Your Reference
Our reference : DOC11/56157
Contact : Rod Fox on 9995 6839

**RE: WestPark Industrial Estate, Chemical Storage and Distribution Facility (SSD-4953)
Notice of Exhibition**

I refer to your letter dated 7 December 2011 seeking the Environment Protection Authority's (EPA) comments and General Terms of Approval (GTA's) on the above Development Application and supporting Environment Impact Statement (EIS) titled "*Environmental Impact State Dangerous Goods Storage Facility 23-107 Erskine Park Road, Erskine Park NSW (Lot DP 1128233) dated November 2011*" prepared by McKenzie Group Consulting.

Figure 5: Proposed Internal Floor and Storage Plan for Building B1

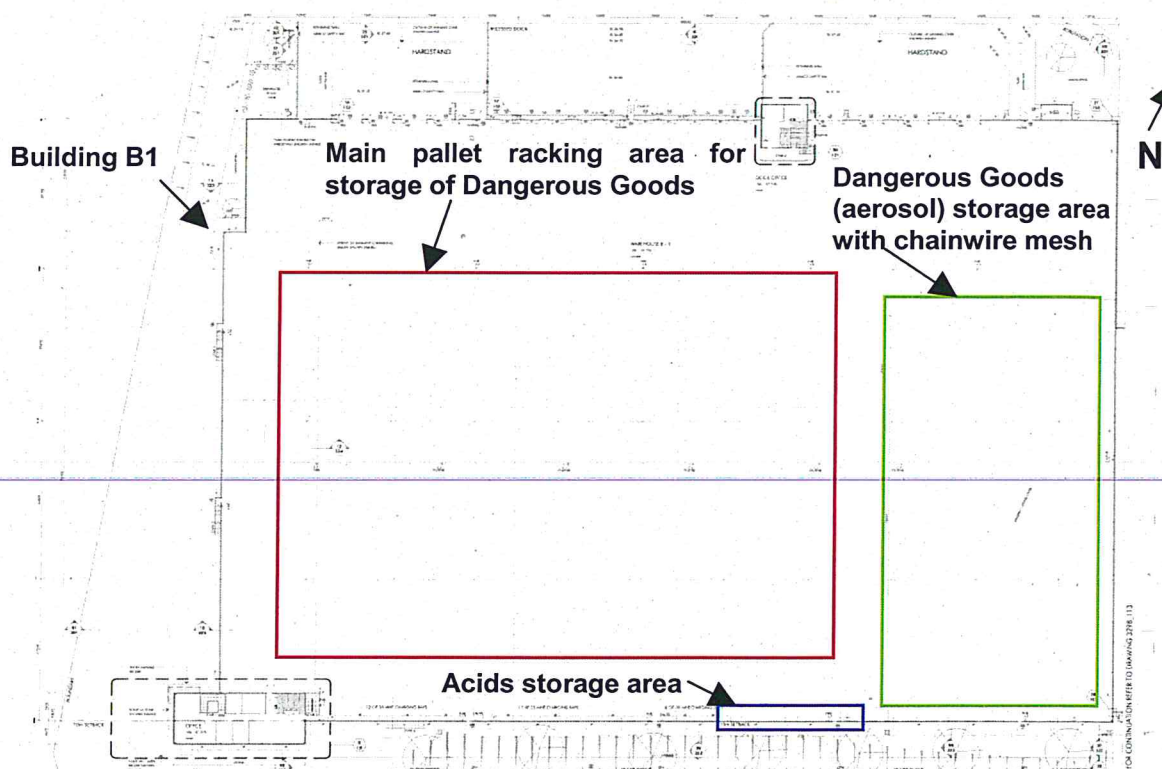
- Design specification and detailed drawings on the proposed bunded areas. The information must include how the bund will be constructed and what materials will be used (no impervious material to be used).

- Detailed drawings and specifications of the firewater containment system. The drawings provided are too small to view properly and do not contain sufficient information. Additional information needs to be provided on how the firewater will be contained if a fire occurs during a rain event.

- Details, specifications and location of the proposed stormwater isolation valves. The information must clearly outline how the valves will be operated. A maintenance plan for the valves must also be provided.
